Planning Application Ref: **AW/281/18/T**

Location: **25 Rucrofts Close, Aldwick Fields, PO21 3SL**

Description of works: **Crown reduction of 3m to 1 No. Lombardy poplar tree & Crown thin of 10% to 1 No. horse chestnut tree**

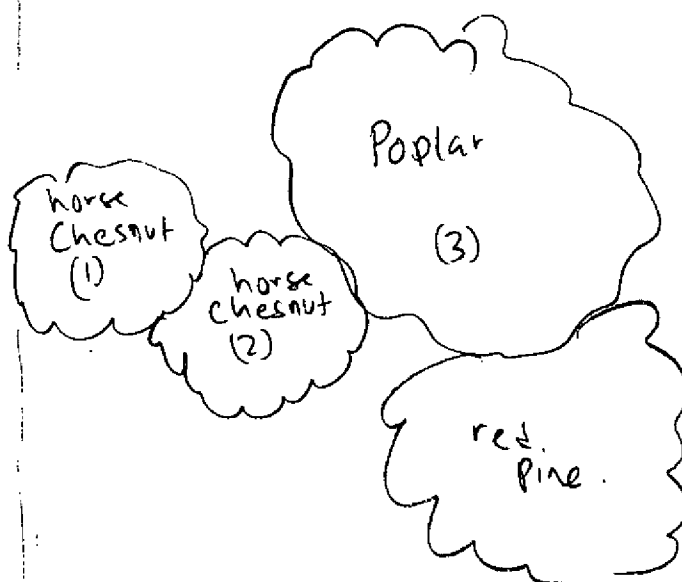
- T1/2 Actually a twin-stemmed individual tree, in apparent fair condition although slightly suppressed by larger companion trees and consequently of drawn-up form.

- Crown thinning is sought primarily to attend to crossing/weak branches.
- T3 appears to be in a fine physiological state. It has multiple low stem unions at different heights. Tall and leggy scaffold limbs will no doubt oscillate alarmingly during episodes of exposure to high wind speed although clearly it has endured to date.

- T3 - The long-term vitality of this tree is best respected when significant pruning work such as proposed, is undertaken during either the summer (mid-June to mid-September) or mid-winter (mid-December to mid-February) periods. Ideally, the work proposed should only be undertaken during these periods.

- I recommend **CONSENT** for this application, subject to the following conditions:

- Where whole branches are to be removed and final cuts made close to the trunk or branch union they are to be made as shown in Figure 2 of BS3998:2010
- Where branches are to be shortened back the final cuts are to be made at the correct angle shown in BS3998:2010 and adjacent to a live bud or lateral.
